19 October 2021

Melissa Anderson
Environmental Assessment Officer
Resource Assessments
NSW Department of Planning, Industry and Environment

Newstan Mine Extension Project: Advice on EIS (SSD-10333) – EMIN21-00014

Predicted subsidence contours

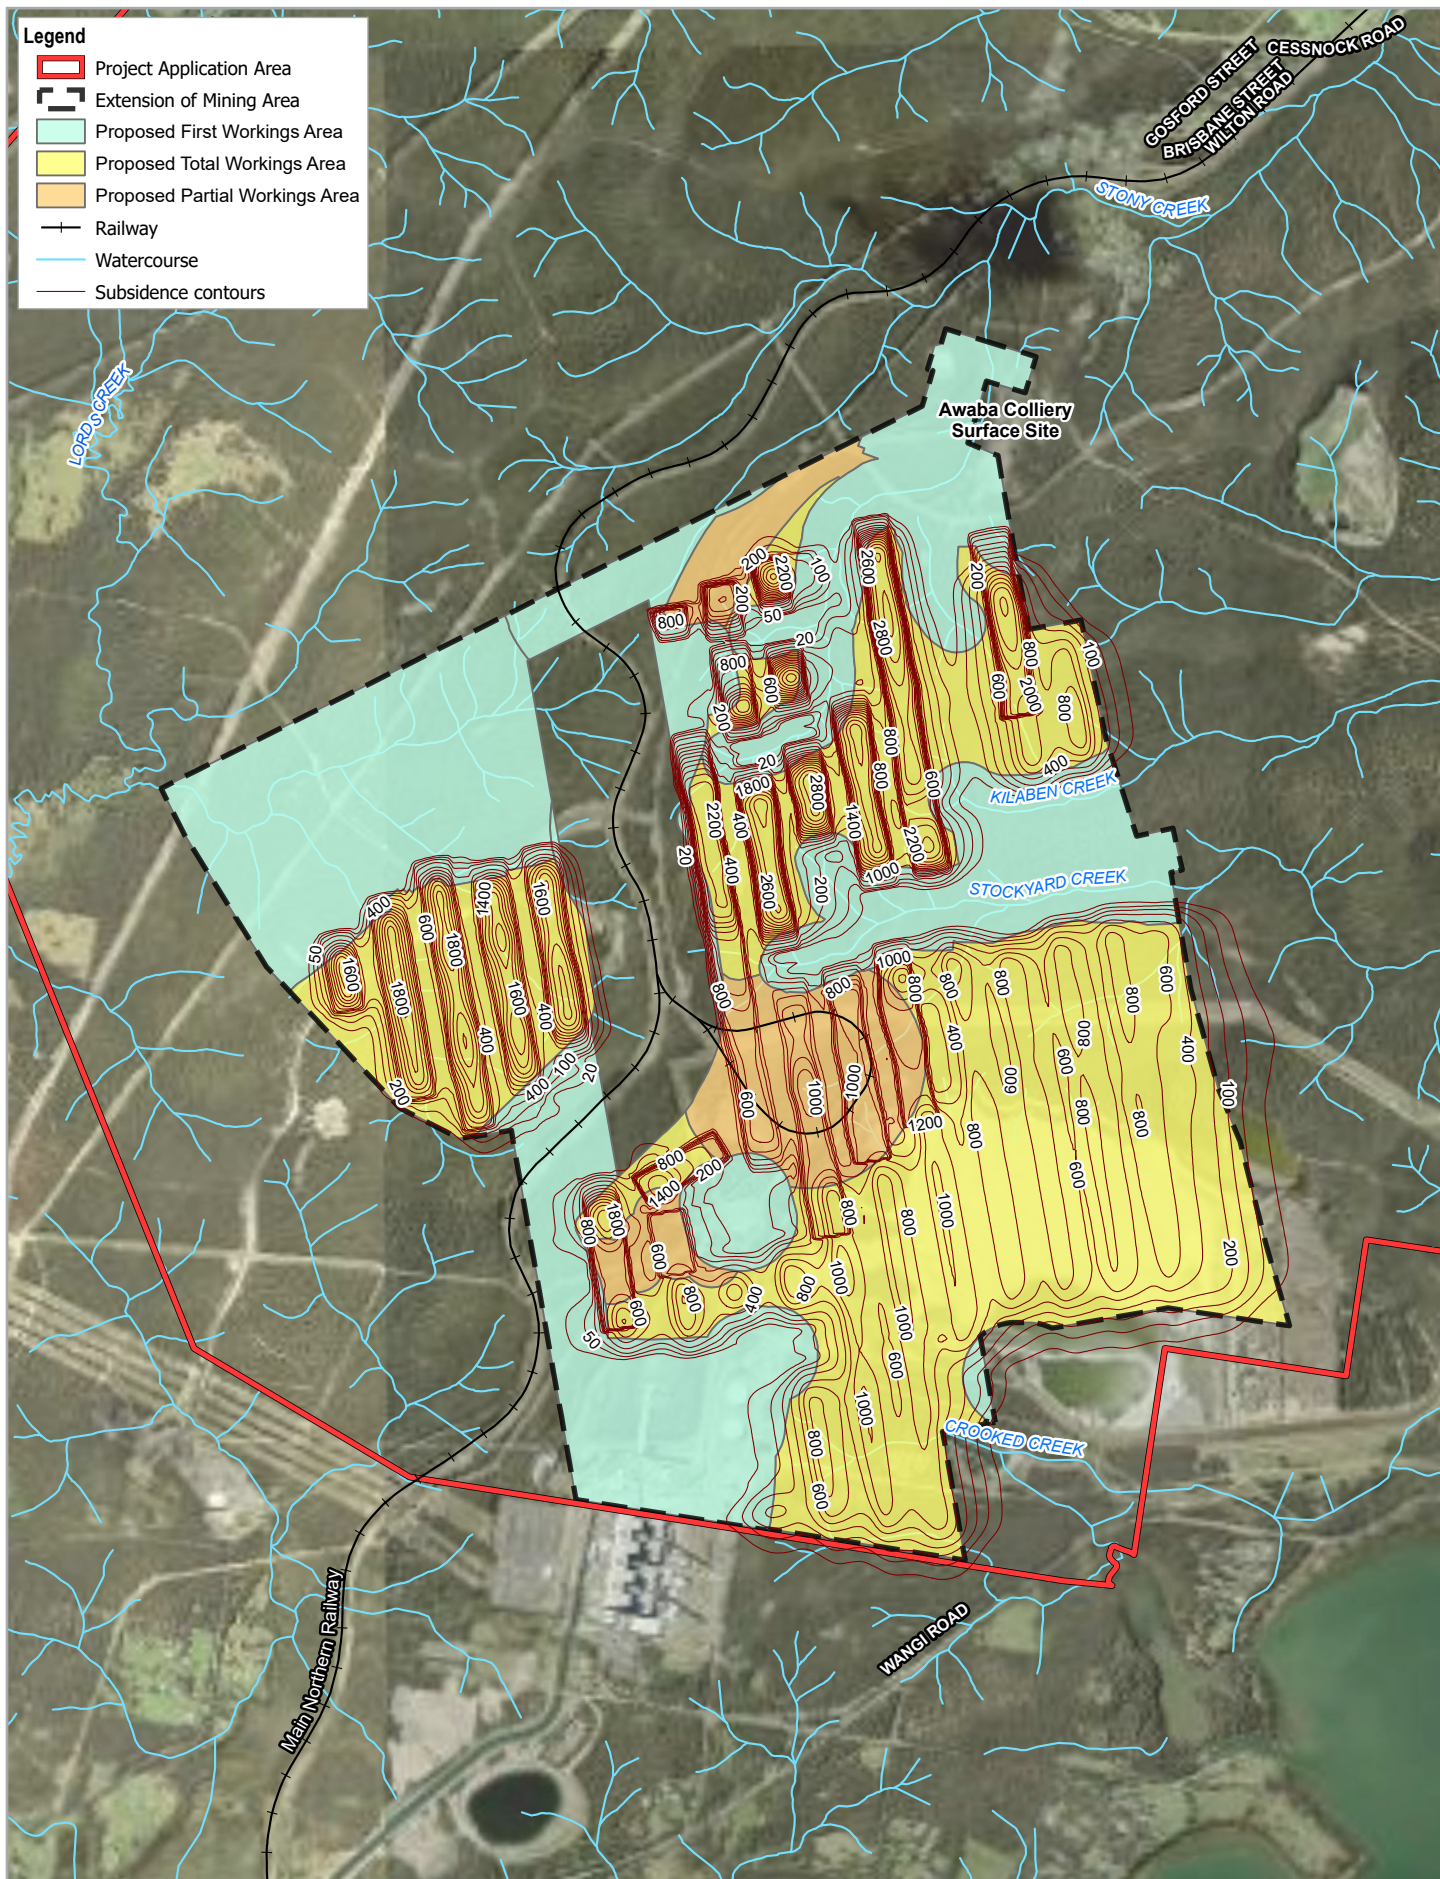
The EIS includes an assessment of subsidence impacts for future underground coal extraction under Eraring power station, Eraring power station ash dam and rail loop. The EIS does not include an extraction plan or detailed subsidence management plan for the power station and associated infrastructure.

It is recommended that prior to further advancing the project, that a more detailed extraction plan and associated subsidence management plan for Eraring power station and associated infrastructure is developed. It is also recommended that the extraction plan include an assessment of long-term pillar stability and an assessment of pillar bearing capacity and roof “punching” failure.
